**City of Portland, Maine - Building or Use Permit**

<b>Permit No:</b> 04-1620	<b>Date Applied For:</b> 10/27/2004	<b>CBL:</b> 261 B063001
------------------------------	--	----------------------------

<b>Proposed Use:</b> Single Family Home / Amendment to Permit#041267 Scaling back original plans	<b>Proposed Project Description:</b> Amendment to Permit#041267 Scaling back original plans
---	--

Plot Plan

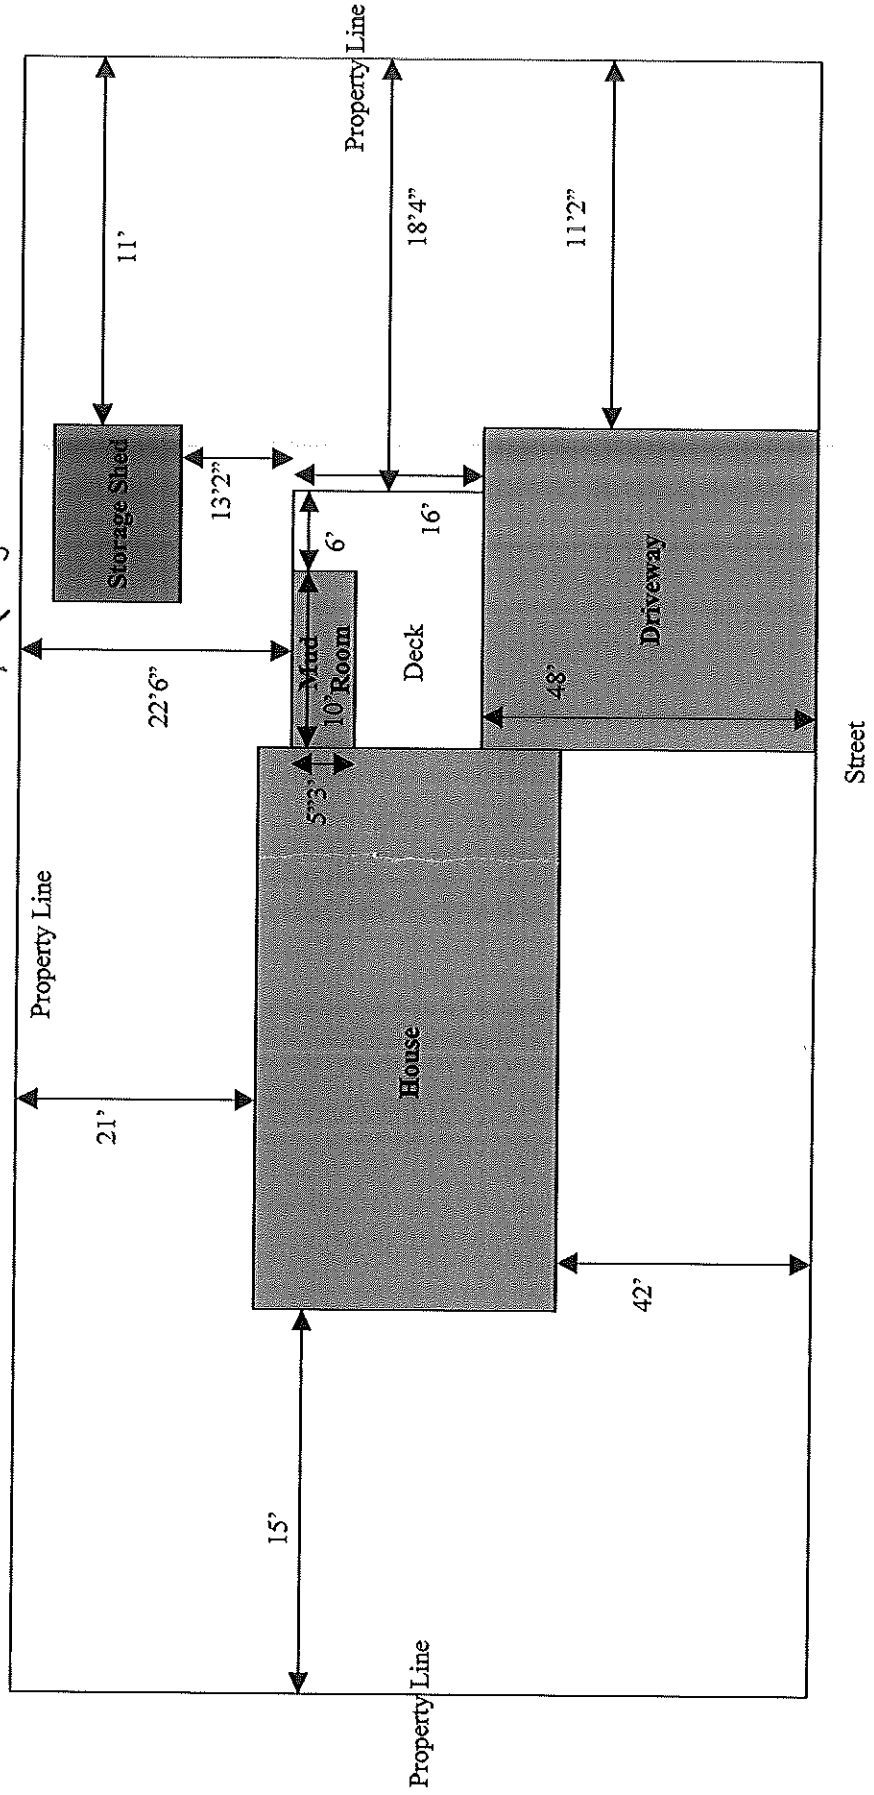
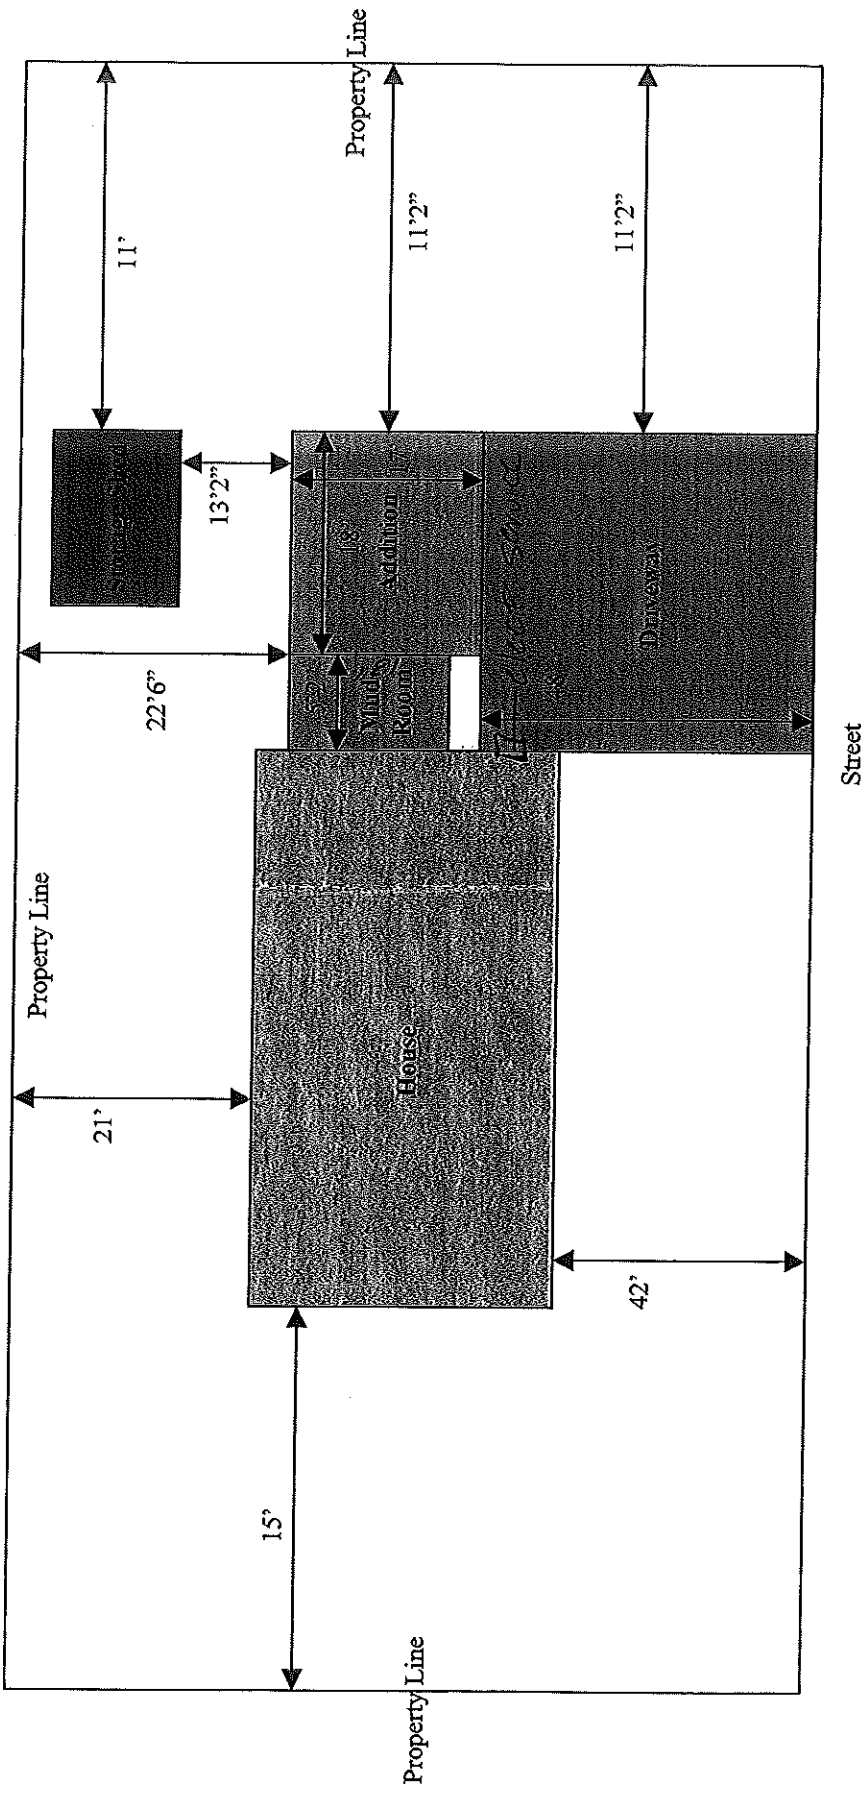
**Dept:** Zoning      **Status:** Approved      **Reviewer:** Tammy Munson      **Approval Date:** 11/10/2004  
**Note:** ok under 14-433 for rear setback to be reduced.      **Ok to Issue:**
